Application for a Non-Material Amendment Following a Grant of Planning Permission

Single storey rear and side extension with pergola, rear and side box dormer loft conversion. New roof lights to front elevation.  
Application of seam metal to existing rear roof

23/00820/FUL

PLANNING	
Client: Mr & Mrs Roberts	
Project: 67 Crosby Road, West Bridgford	
Drawing: Proposed Elevations	
Number: 22.378.S03.02 B	
Date: 09/22	
Paper Size: A3	Scale: 1:100
Drawn By: AA	Checked By:

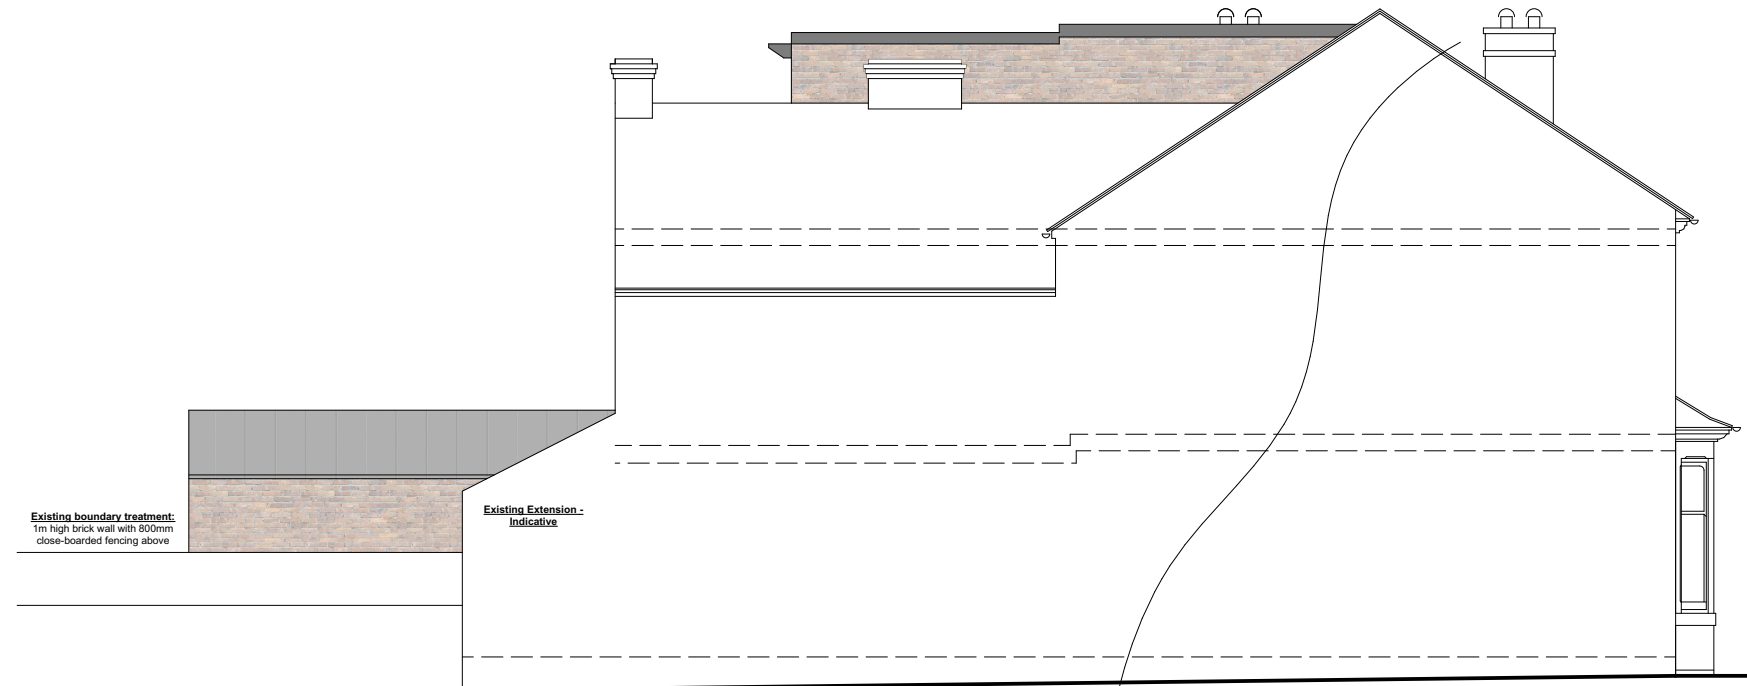
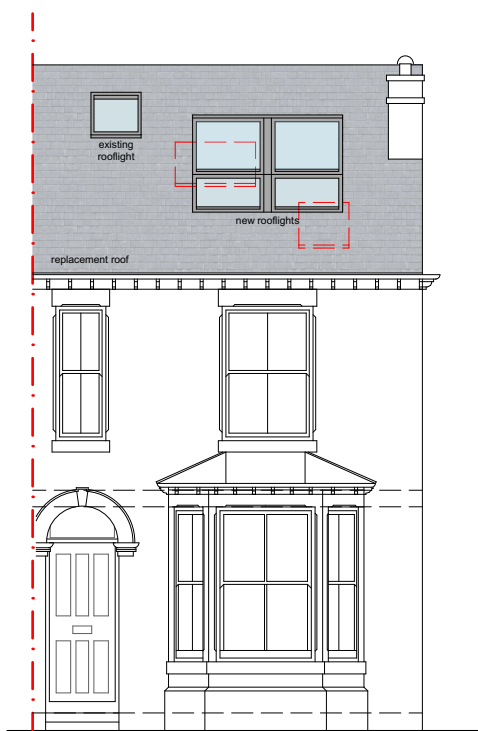
Reducing from 3 roof lights to 2 on front elevation, also changing the standing seam on the party wall elevation to brick to match existing.

Only 2 roof lights required, and changing from standing seam to brick to match existing.
